# Rezoning Transportation Analysis

Petition Number: #2022-079

The petition is located on the west side of Kenilworth Avenue, a City-maintained major throughfare and south of Pearl Park Way, a City-maintained local street. A Traffic Impact Study (TIS) was approved by CDOT on 4-14-23. Site plan revisions are needed to meet ordinance requirements and/or the outstanding items including, but not limited to removing right-in only access on Kenilworth Avenue. Further details are listed below.

RZ - 200

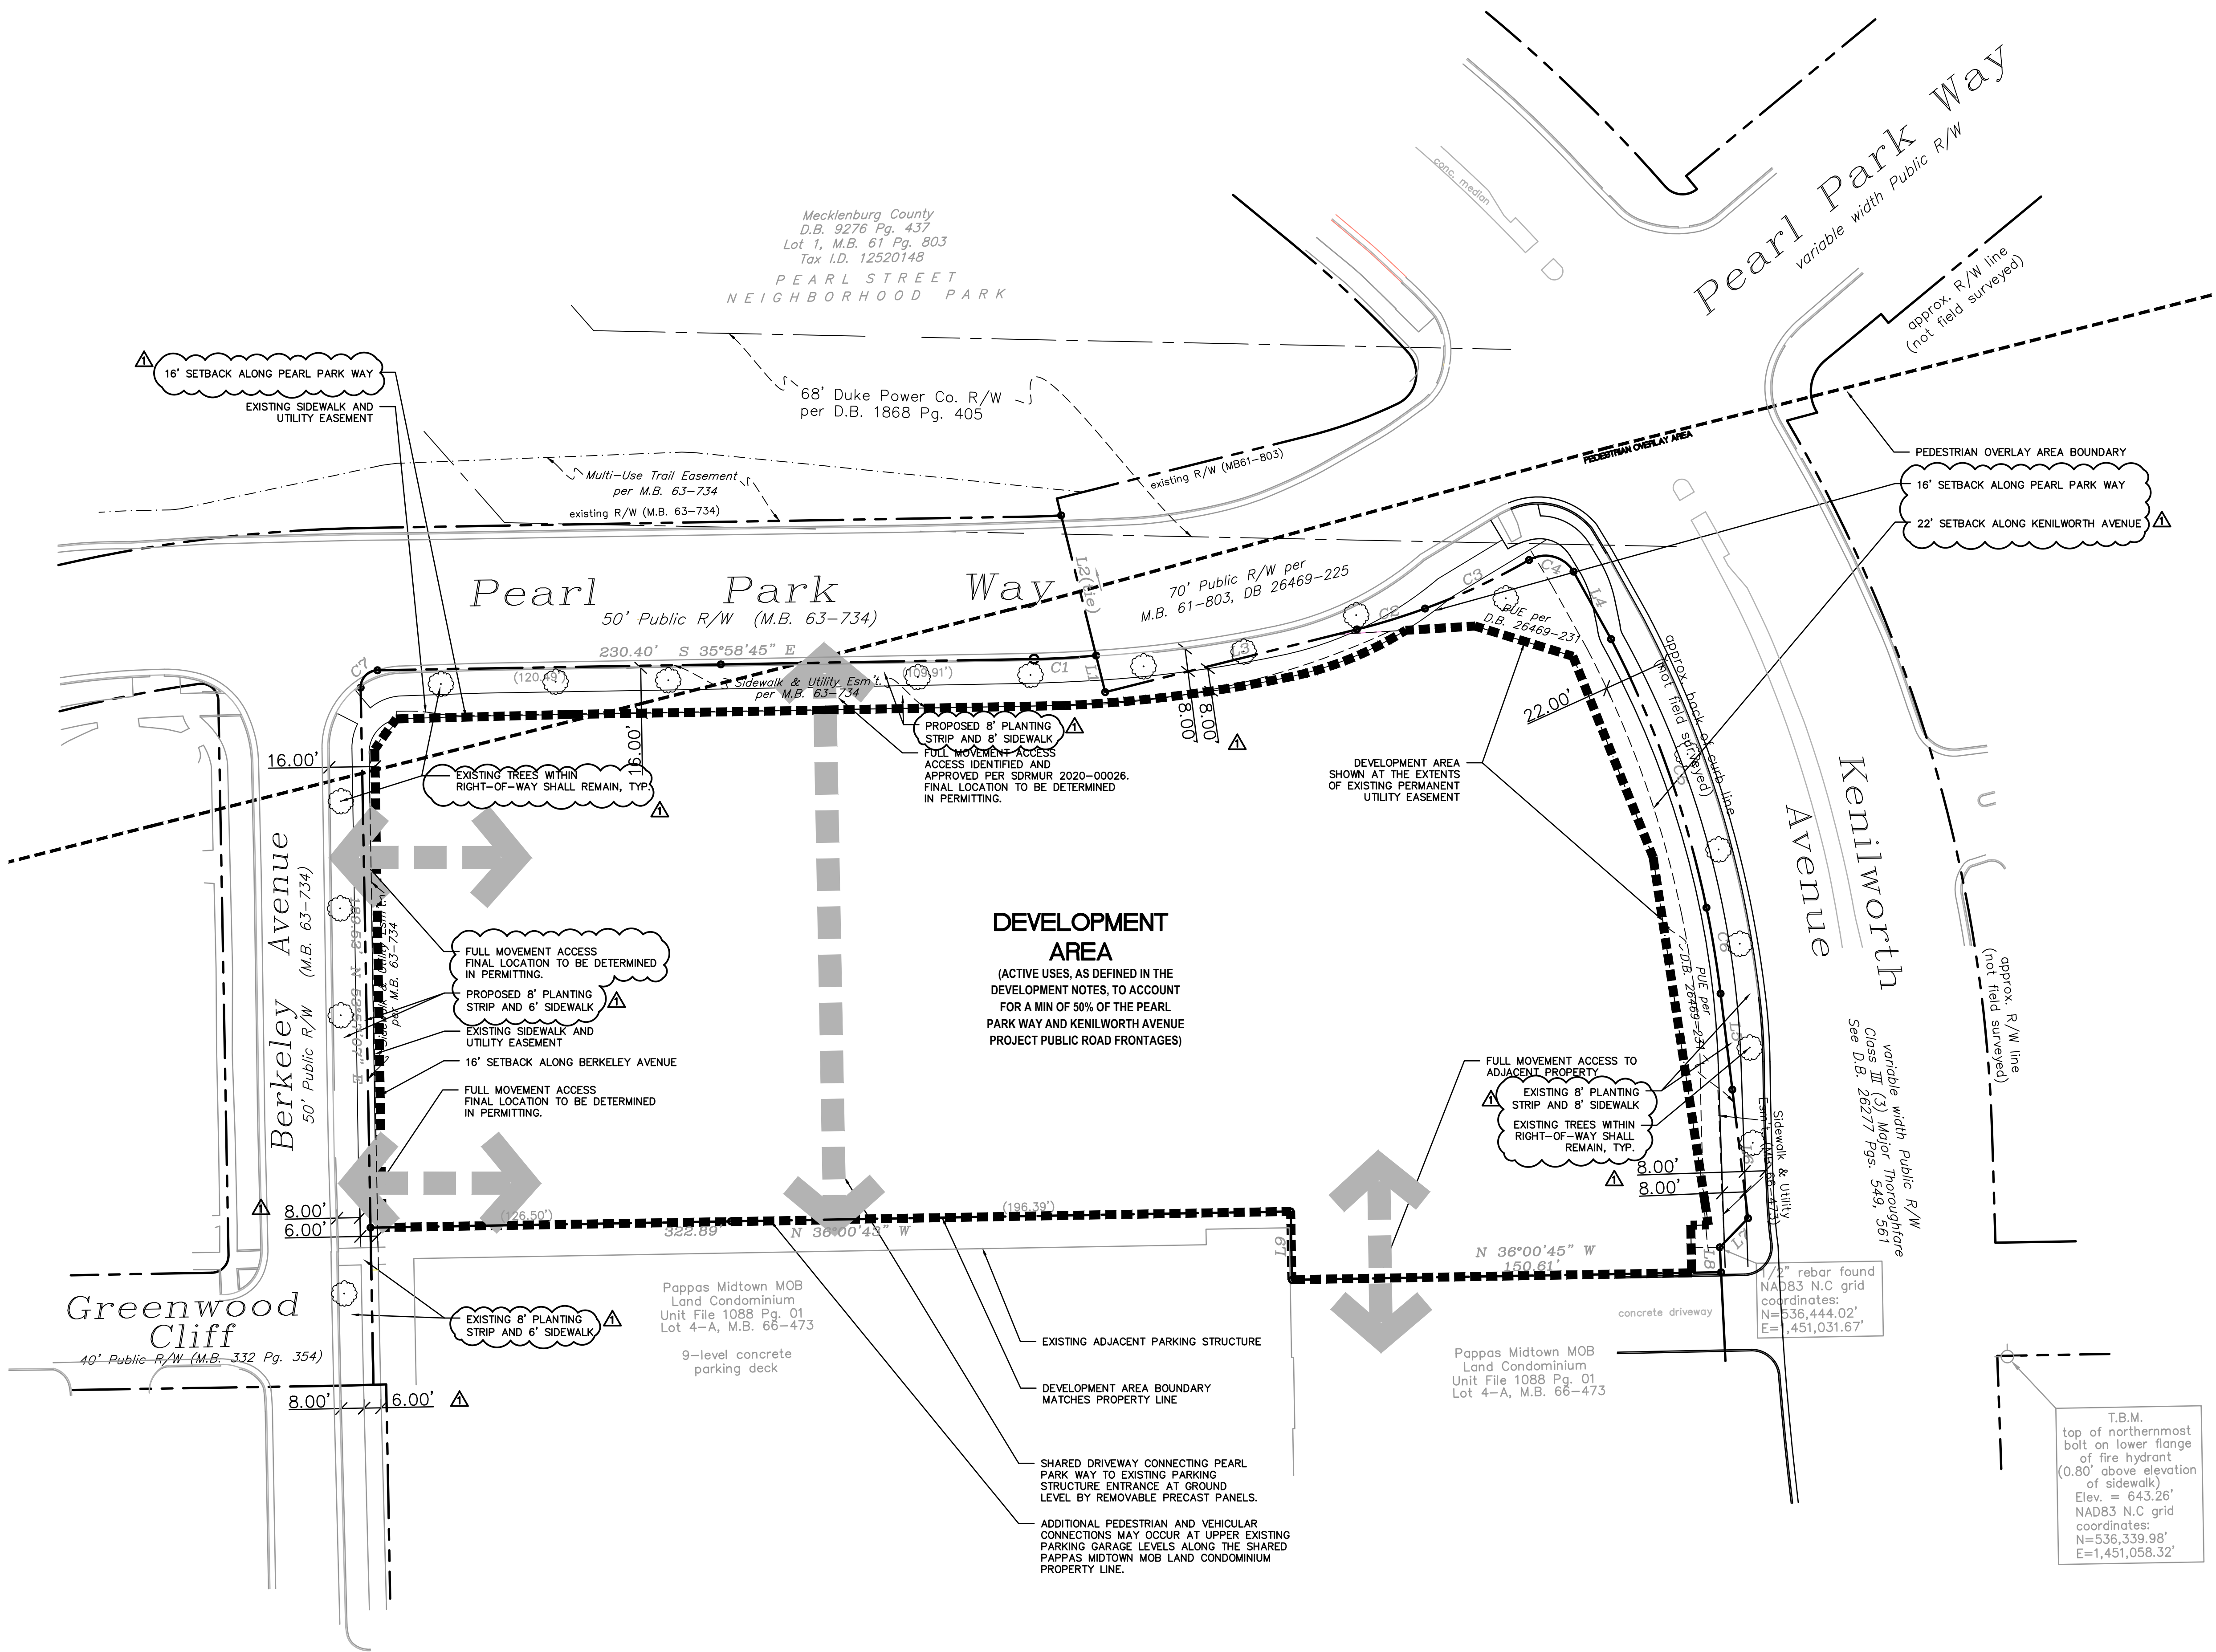
**Outstanding comment 12-22-22:** Label and dimension the curb and gutter from the centerline for each road on the site plan.

RZ - 200

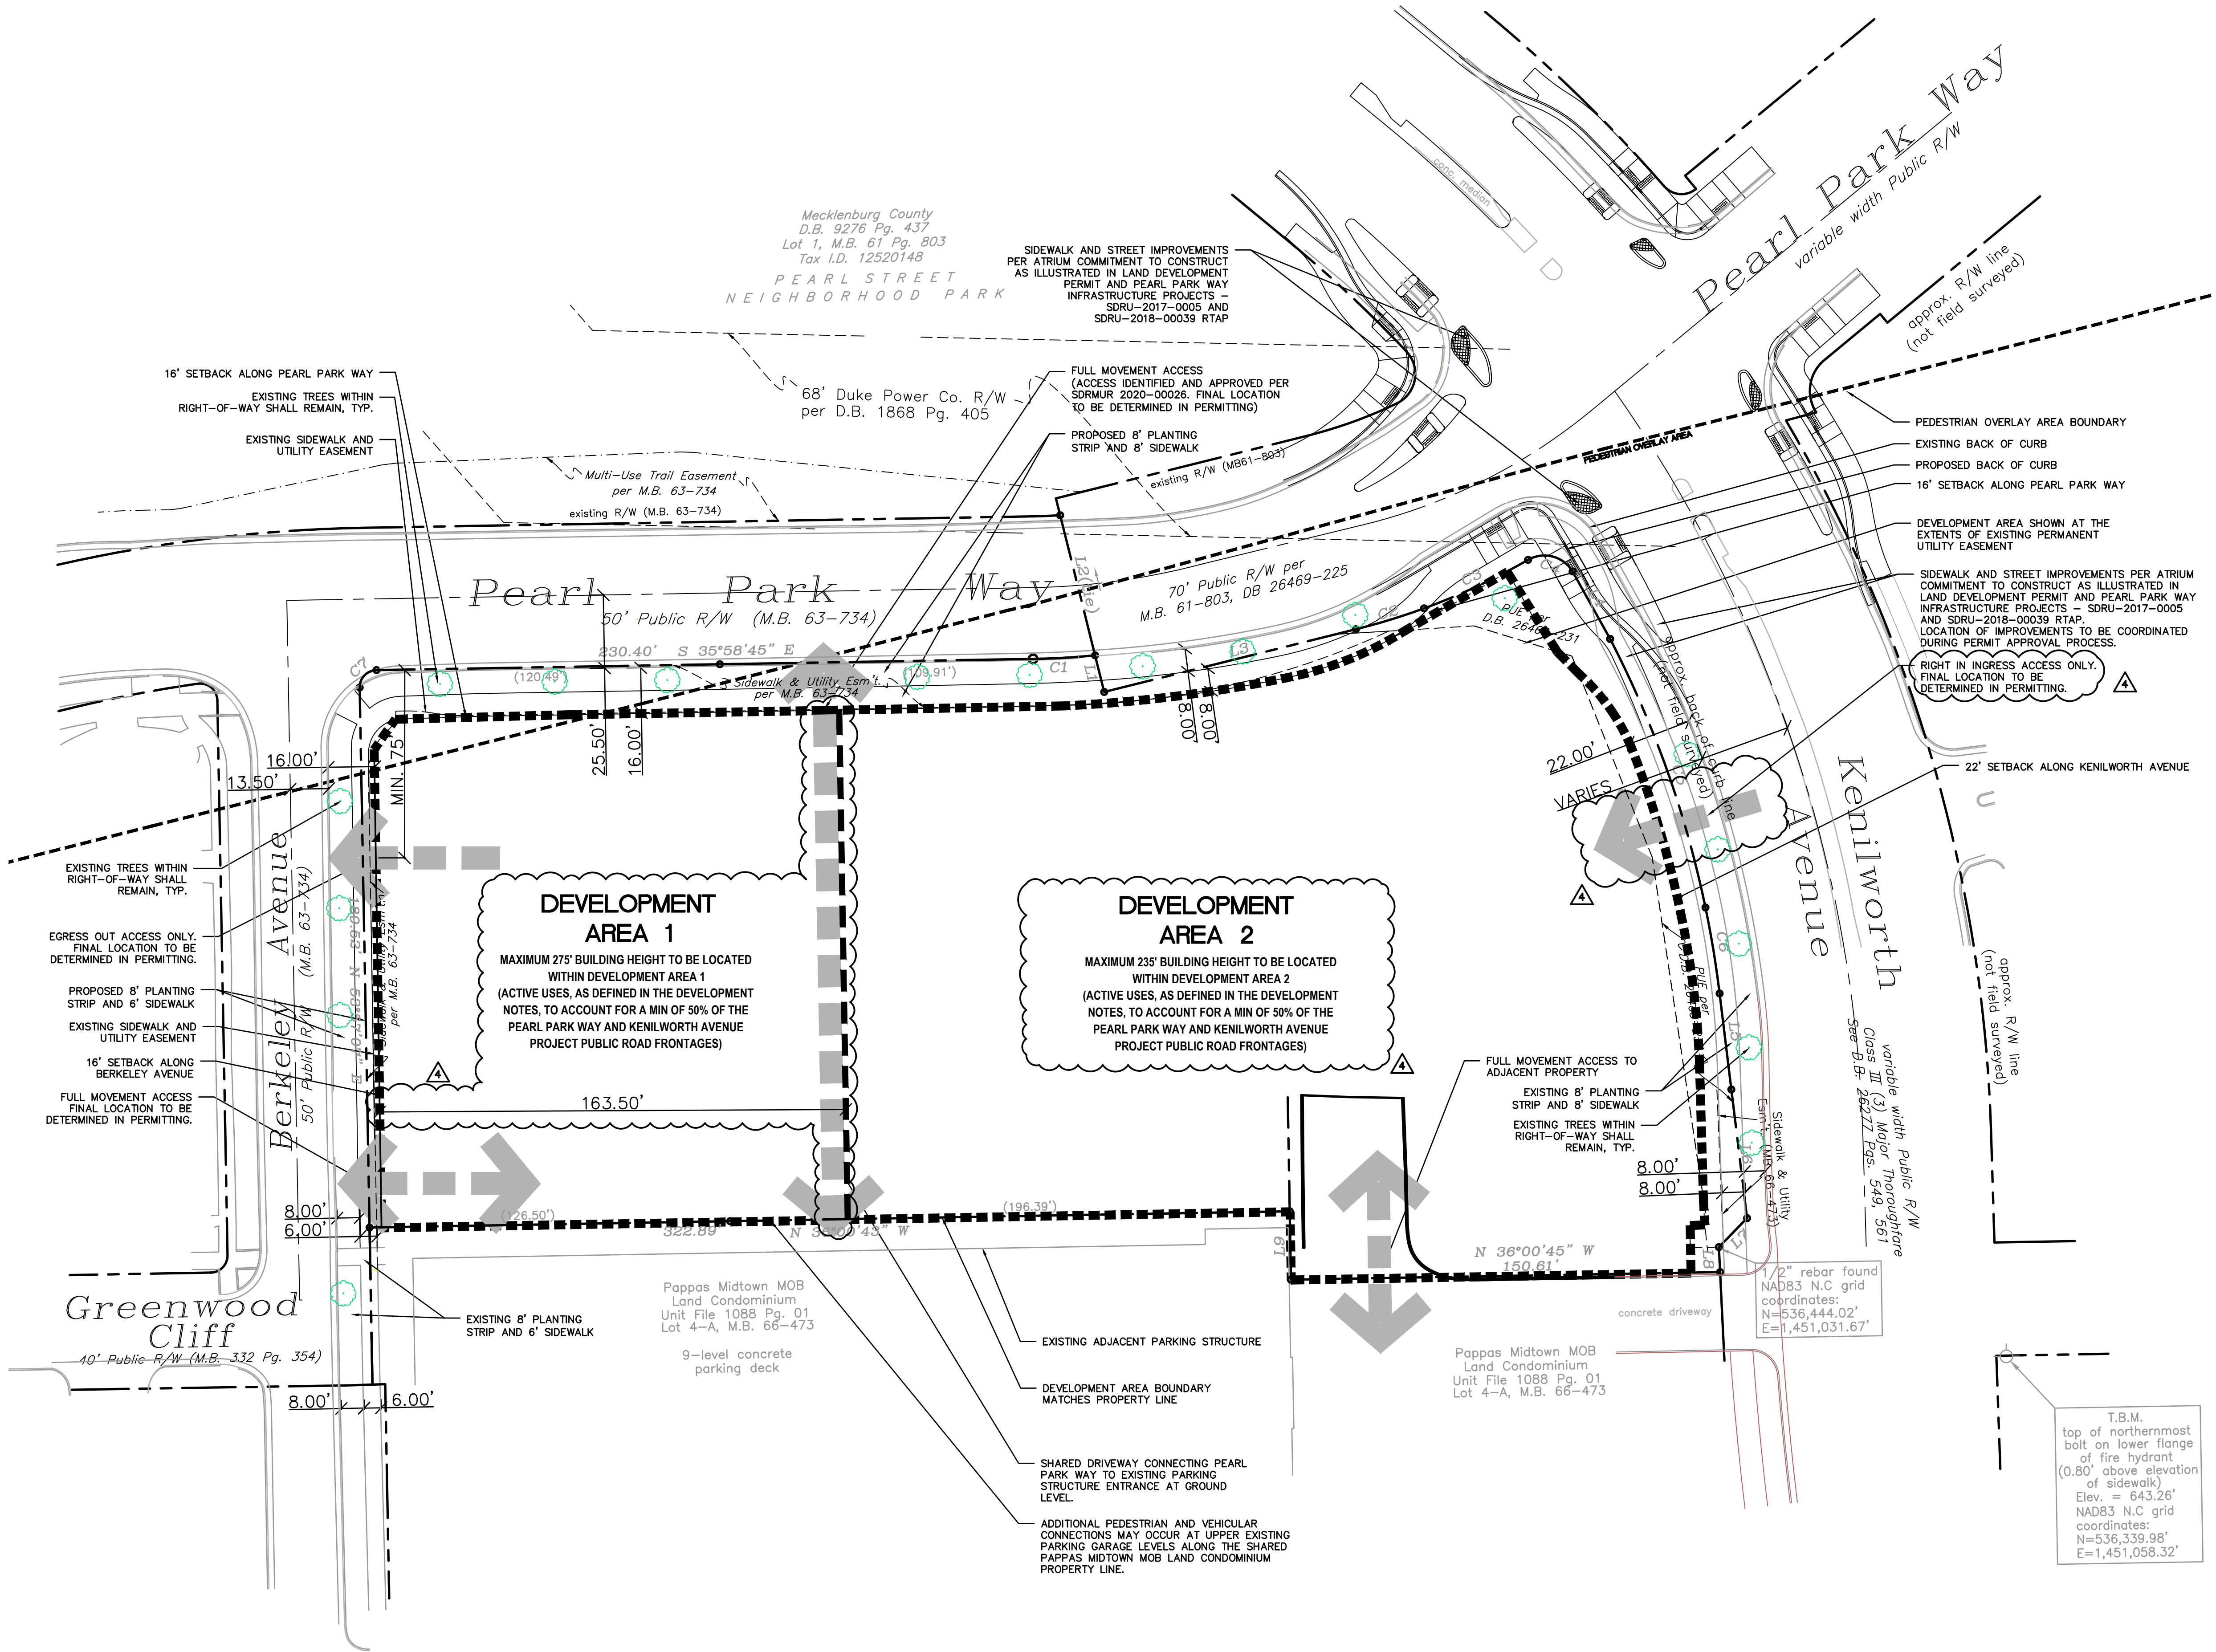
3. **New Comment 11-27-23:** Revise site plan and conditional note(s) to remove the proposed right-in only access on Kenilworth Avenue. Access on Kenilworth Avenue does not meet driveway spacing requirements with respect to adjacent driveways, distance to signalized intersection, and conflicts with future protected intersection improvement. The site plan should be redesigned to access the site from Kenilworth using the established shared access point south of the petition.
